# CITY OF ALBUQUERQUE

**RE: Sequoia Apartments**  
**8100 Sequoia Rd. NW**  
**Grading and Drainage Plan**  
**Engineer's Stamp Date: 02/22/2022**  
**Hydrology File: G11D058**

Based upon the information provided in your submittal received 1/4/2022, the Grading & Drainage Plan **is not** approved for Building Permit. The following comments need to be addressed for approval of the above referenced project:

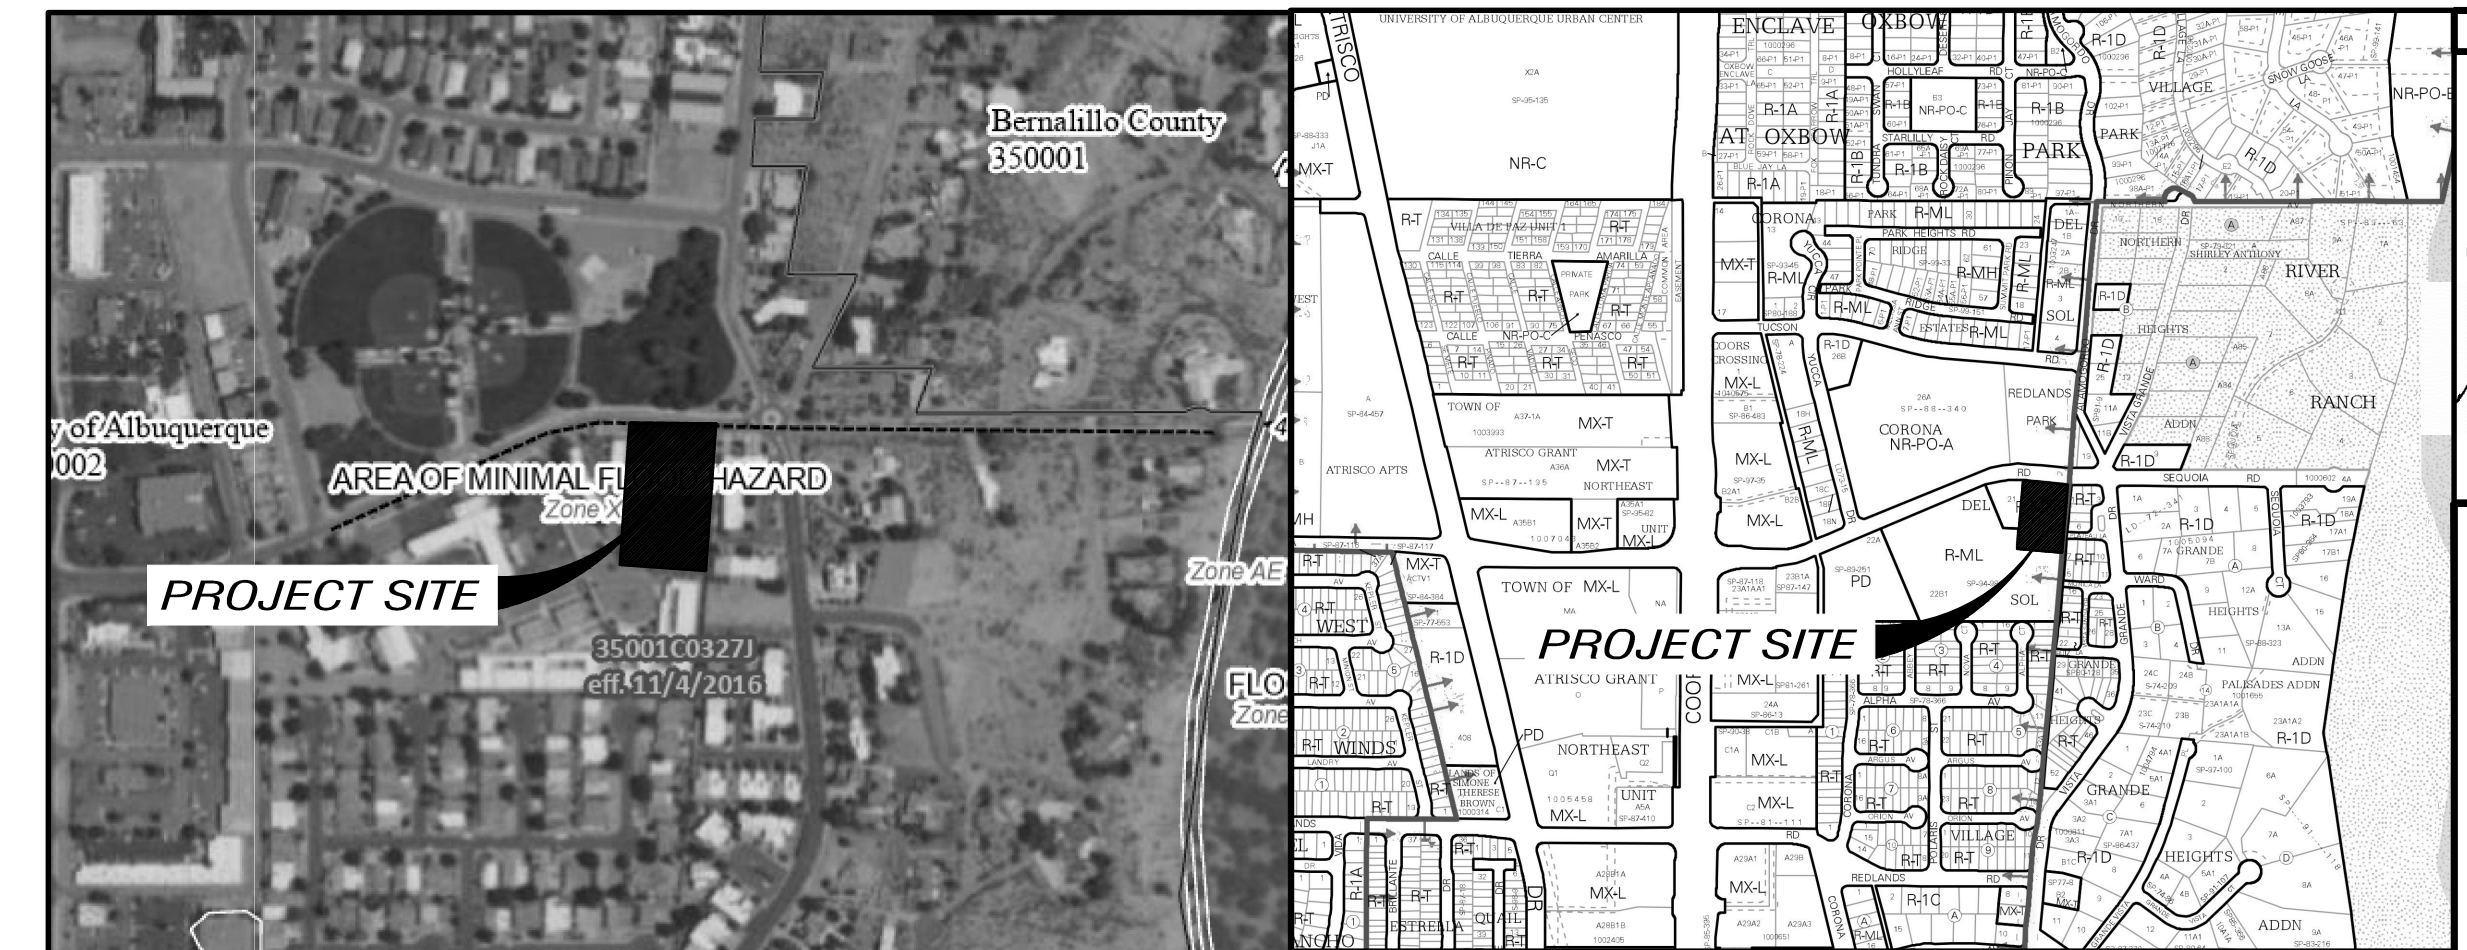
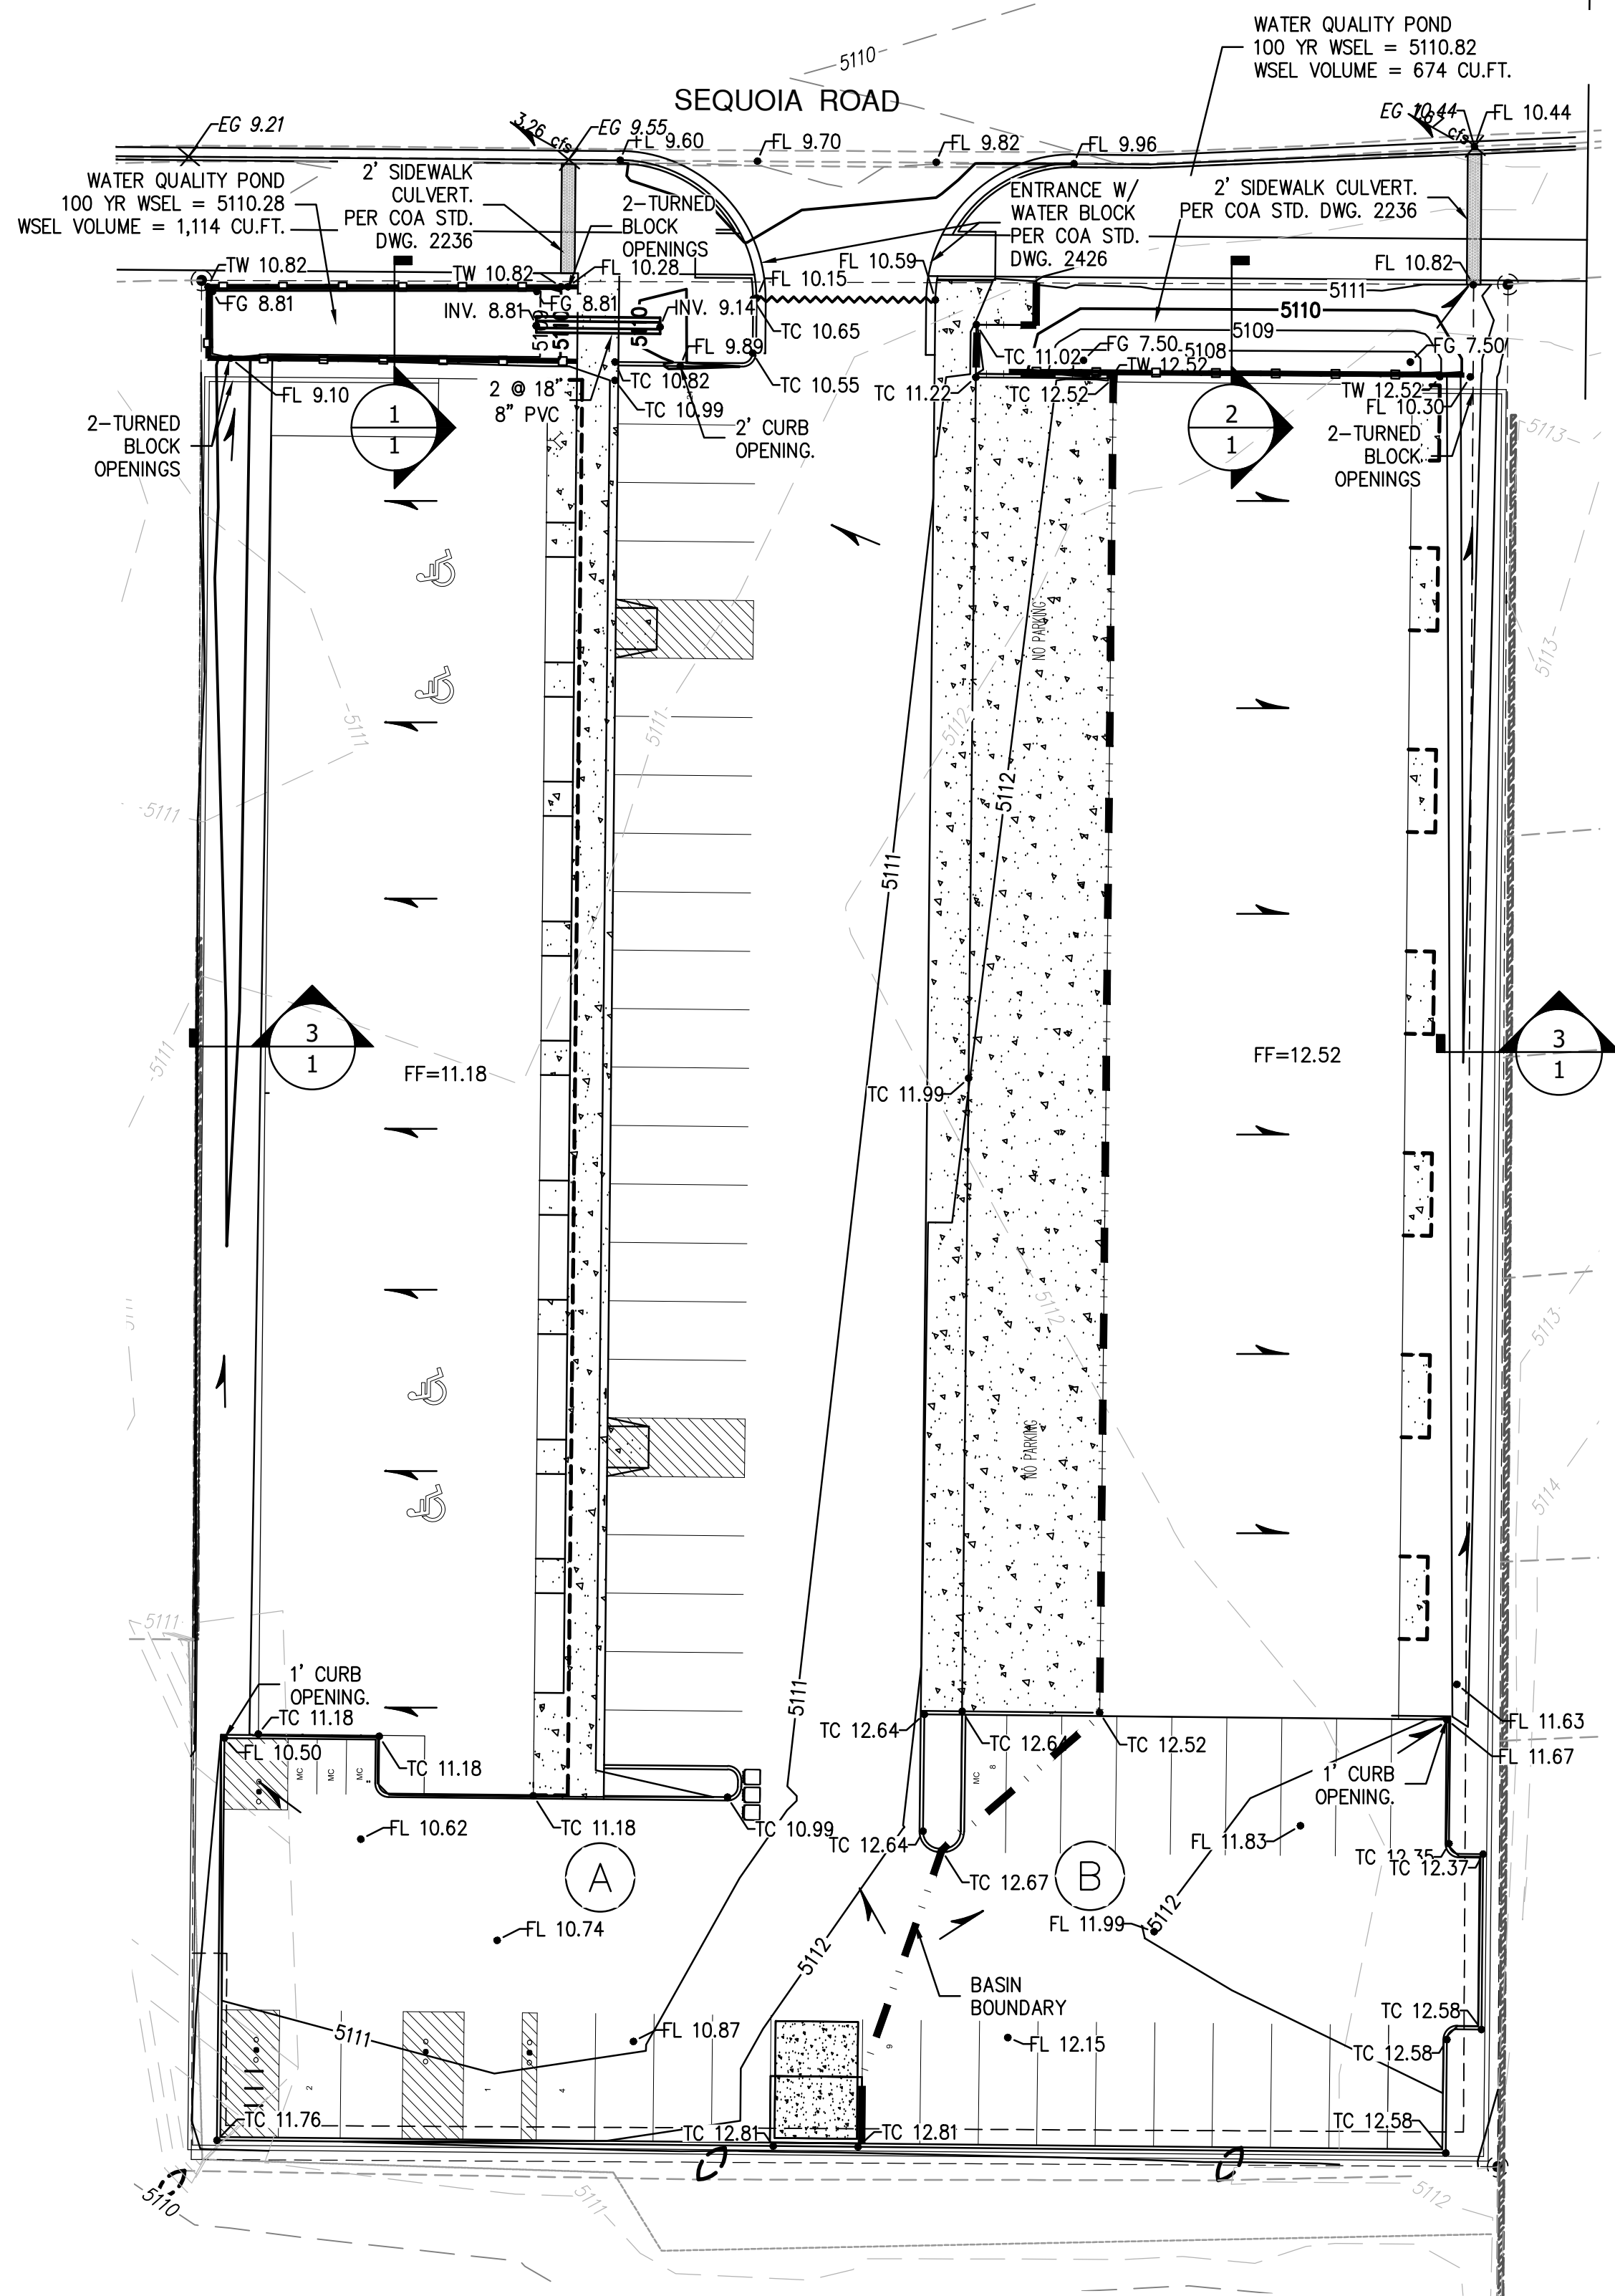
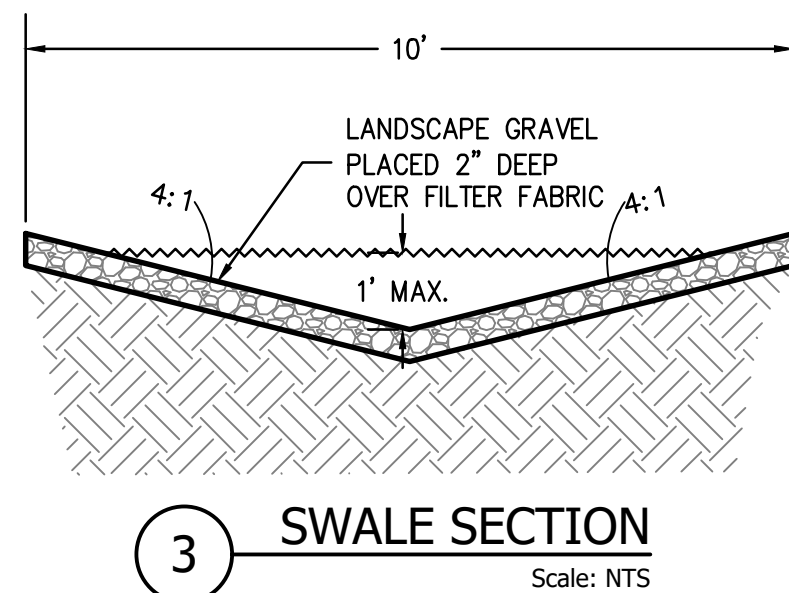
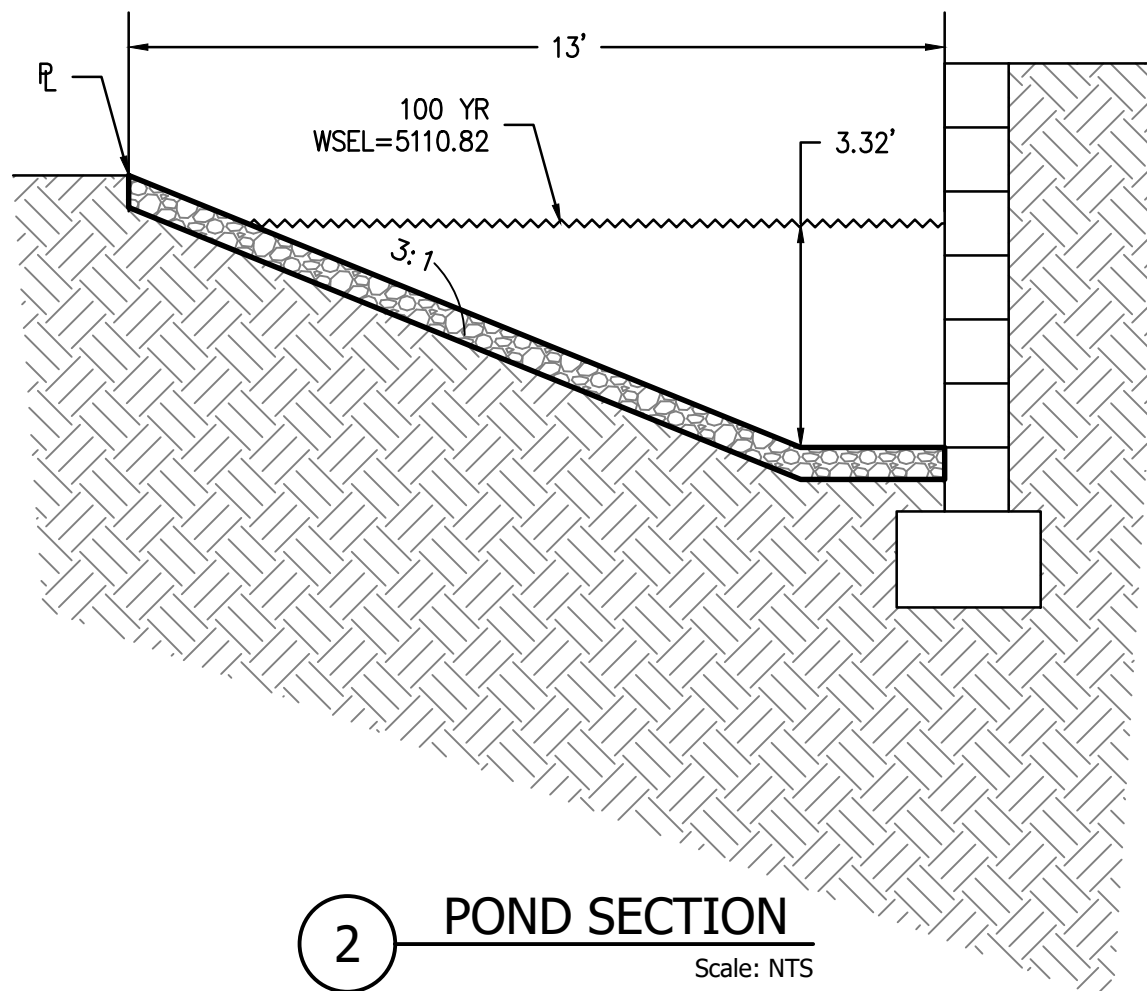
1. Please provide swale details.

- a. 
2. Please include the survey data.
    - a. What are you tying into.
  3. An SO-19 Permit will be required and should be included on the request. Please include the [standard SO-19](#) notes on the grading plan. (attached)
  4. Please include the street name

5. What are these circles?

6. Please provide sections of the ponds with water surface elevations of storage for the 100 yr.
7. Reference standard details (drive entrance with proper water block – check existing elevations – and sidewalk culverts)
8. Please include project benchmark and datum.
9. Retention is 100 year 10 day volume. If you are going to call out retention, please provide the proper calculations. If it is SWQV, simply state such.
10. Is there a basin break? If so please label the line separating them. It is not clear.
11. Show the roof flow direction and where it discharges to.
12. Please update your notes. You are calling out update no 8. Etc... Please take a look.
13. Please provide inverts on the pipes connecting the larger pond. And please label the ponds for reference to requested sections.
